MEMORANDUM

Date: April 17, 2024

Subject: Raising Cane's Restaurant SWC of St. Joseph and Coors Site Plan

SHEET NUMBER
C5.0

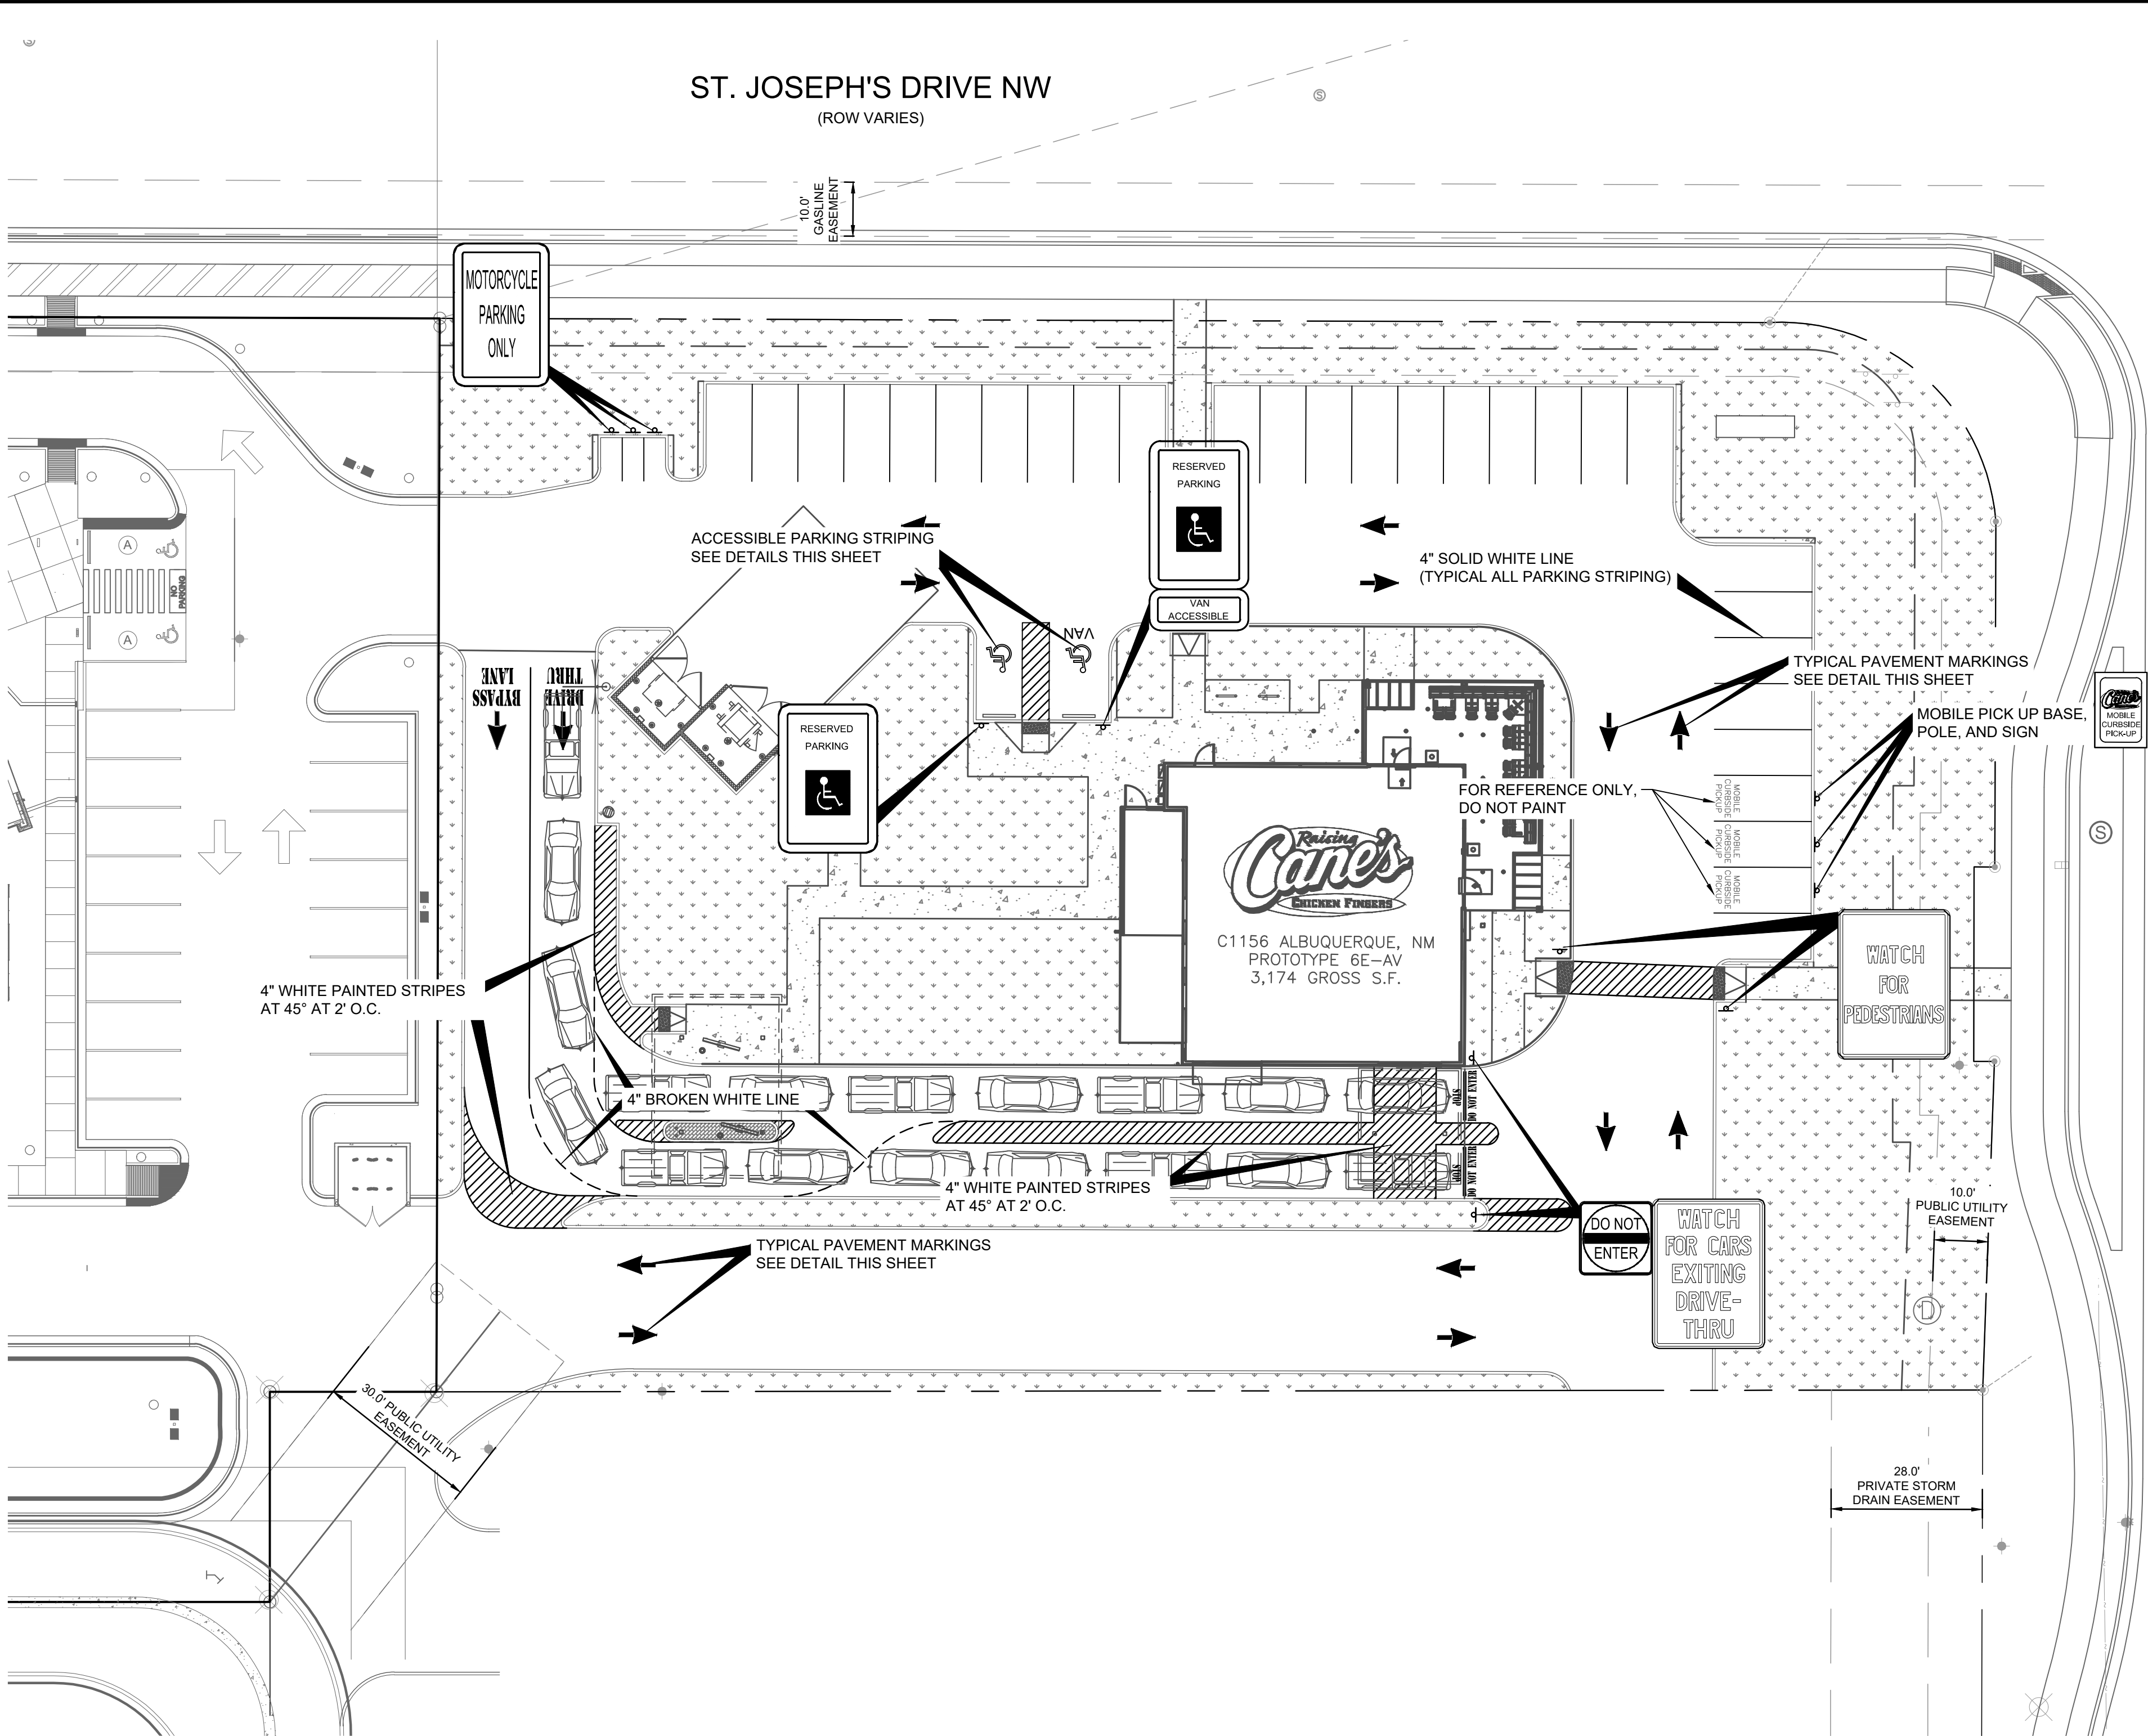
Comment 1: The entrance/exit at the private circulation road appears to have vehicles entering and exiting from three businesses with the Raising Cane's entering/exiting on a 45 degree angle at a 90 degree bend in the road. It is not clear how this intersection will function. The 2024 02 06 Oxbow Composite Plan Model (1)-Developer.pdf shows a better intersection as the Lot 6 entrance is 100 feet or more south of the 90 degree bend. This issue was discussed with Sydney (sp?) at Kimley Horn and we discussed showing the curb line across Lot 6 per the 2024 02 06 Oxbow Composite Plan Model (1)-Developer.pdf.

Comment 3: It appears you are proposing ½ or so of a landscape area along the southern boundary. The 2024 02 06 Oxbow Composite Plan Model (1)-Developer.pdf shows parking spaces in this location. Please coordinate with the project on Lot 6 or the Developer to figure out what is to be built in this area.

Comment 5: Provide a detail/keyed note for the bicycle racks. Contractors regularly install racks that don't meet City code. The inverted-U style meet our code as an example. Please let me know if you like more information on rack requirements.

Comment 6: The drive-thru lanes are to be a minimum of 12' wide. The minimum inside diameter radius is required to be 25 feet. Provide the three radii at the bend in the drive-thru. The radii can be reduced to 15', if the lanes are 14' wide.

Comment 7: The minimum stacking requirement is 12 cars at 20' each. It appears the stacking is 10 cars in the drive-thru lane. The length of a car is not provided. It appears the bypass lane is a drive-thru lane due to the location of the order board. How does the bypass lane function?

Comment 9: Please add a note "Broken or cracked sidewalk in the ROW is to be replaced". Landscapers can get carried-away with the skid-steer.

Response: *The entrance/exit at the private circulation road has been revised to remove the additional driveway stub on the east side to lot 6. What is currently shown better aligns with the Oxbow Composite Plan Model.*

Response: *At this time, it is Raising Cane's understanding that the future layout of Lot 6 is not yet determined. The proposed curb line on the south side lines up with the current composite plan for*

Response: Keynote T on sheet C5.0 has been updated to read "proposed inverted-U style bike rack."

Response: The drive-thru lanes have been revised to be 12' wide. The radius at the bend in the drive-thru has been revised to be 25' and has been annotated accordingly.

Response: The second drive-thru lane after the bend will be used daily. Queuing cars can select either drive-thru lane at the bend to order and pick up their food. The vehicles shown on sheet C5.0 using the single drive-thru lane at the entrance and then breaking into two lanes are considered to be Raising Cane's standard queuing operations that will be utilized daily. The total number of vehicles able to successfully queue is 18.

A dimension has been added to a vehicle block immediately south of the building, 20' per vehicle is utilized for design.

The bypass lane can be used by customers if 18 cars have already queued and will function as a second full-length drive-thru lane. The curb cut at the southeast corner allows customers to exit the drive-thru lane before ordering if they choose.

Response: *Site note #8 has been added.*

ACCESSIBLE PARKING DETAIL
N.T.S.

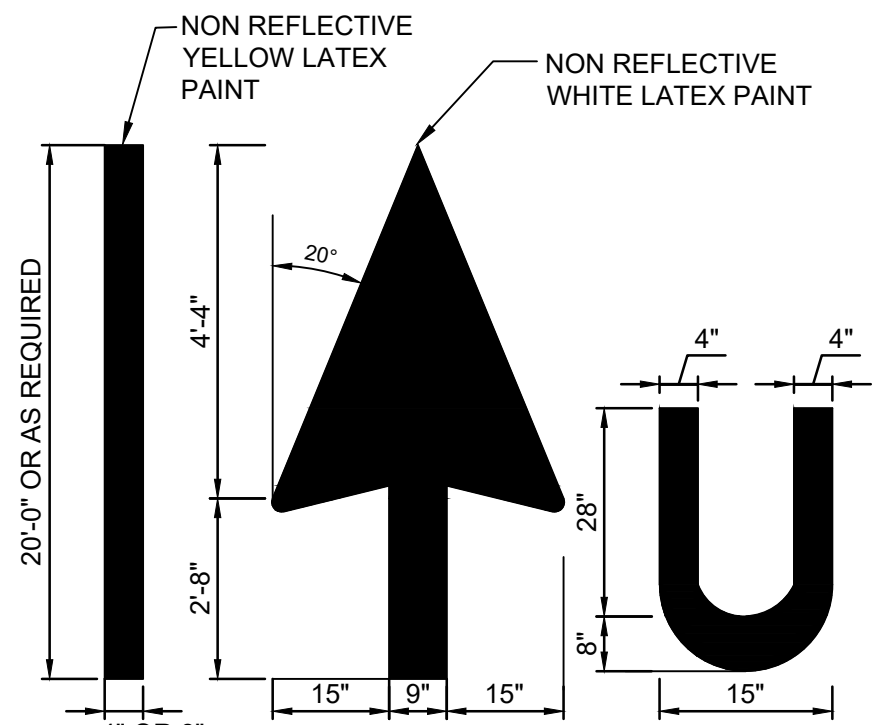
Comment 10: Accessible aisle stripes should be blue rather than white.

Comment 11: The accessible aisle detail has the non-van space as 9.0' wide, whereas the site plan shows it as 8.5 feet wide.

Response: *The accessible parking detail on sheet C5.2 has been updated to call out 4" solid blue latex painted stripes. The accessible parking symbol detail is still specifying white.*

Response: *The accessible parking detail on sheet C5.2 has been updated to reflect the 8.5' dimension shown in plan view.*
